RE: DRAINAGE/GRADING PLAN FOR SPECIAL SYSTEMS WAREHOUSE
(J 14/D48) RECEIVED FEBRUARY 25, 1985

The referenced plan dated February 25, 1985, is approved.

RE: DRAINAGE PLAN FOR SPECIAL SYSTEMS, INC. WAREHOUSE (J-14/D48)
RECEIVED JANUARY 29, 1985

DRAINAGE / GRADING PLAN
SPECIAL SYSTEMS INC. WAREHOUSE
1301 EDITH BLVD. N.E.

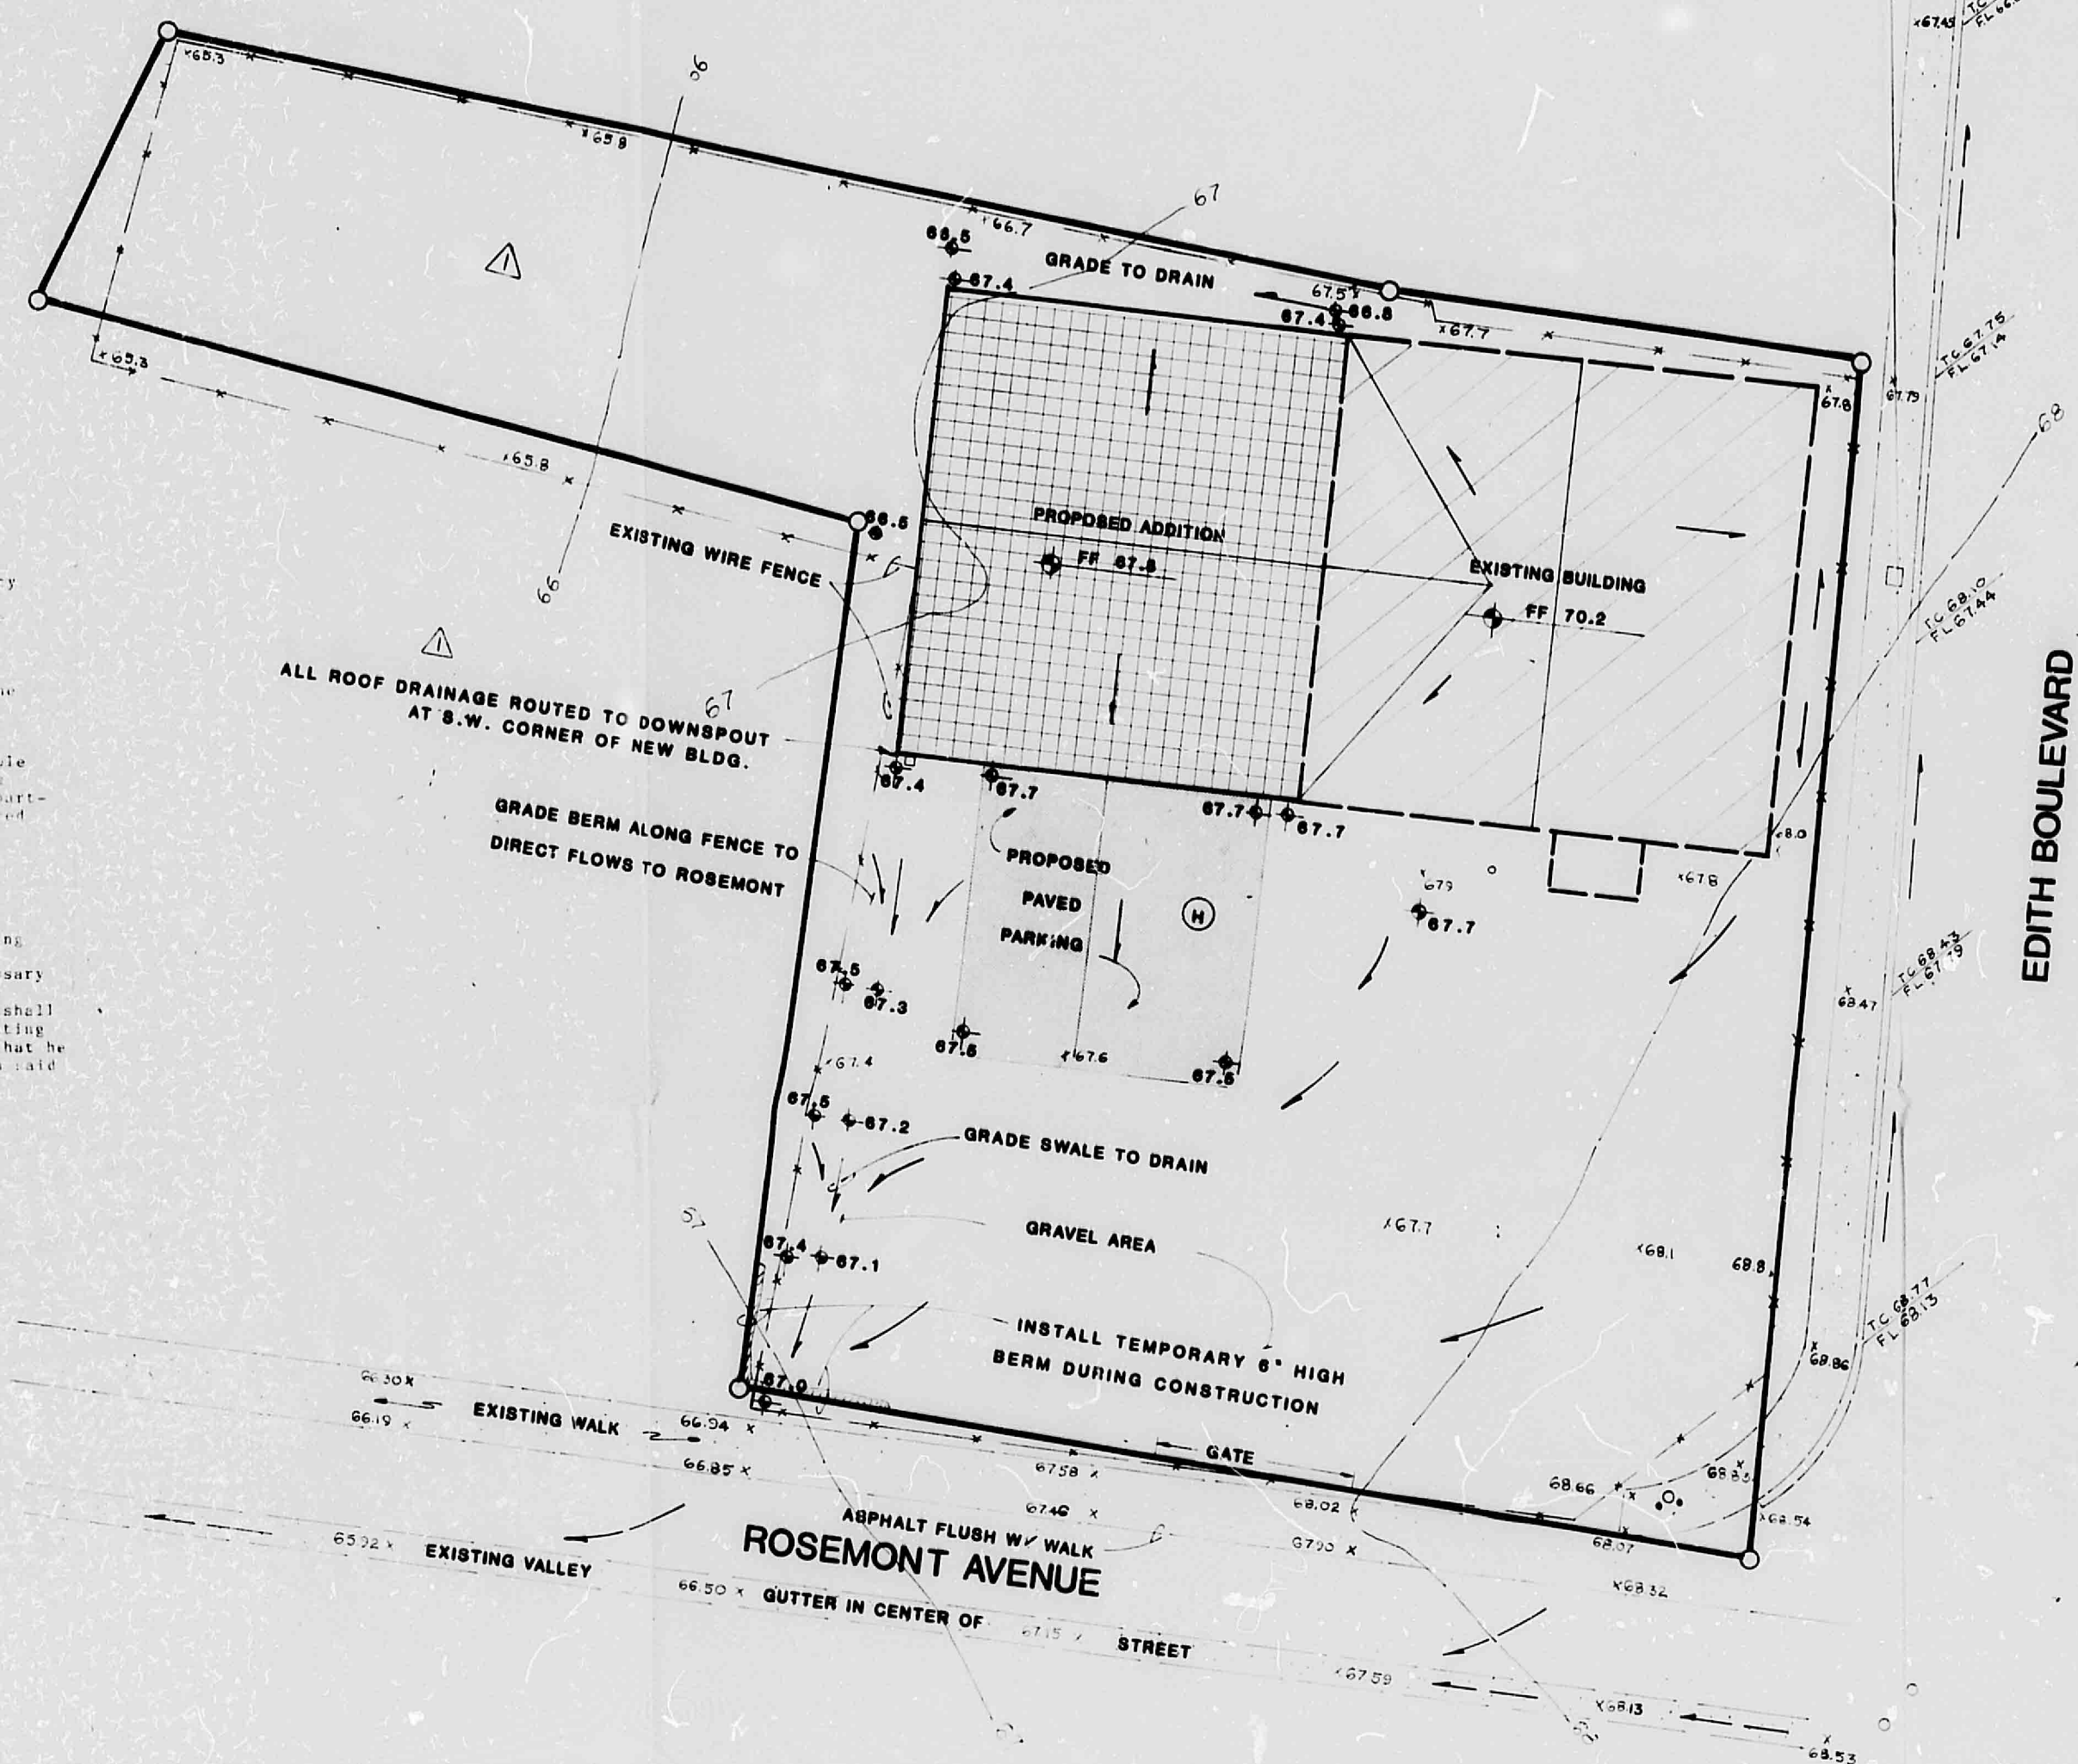
Based on City Ordinance, all ponds must drain within 24 hours. Please indicate the type of outlet that will be used on NW pond. Please submit a plat showing the removal of lot lines or a drainage covenant that allows flow across lot lines.
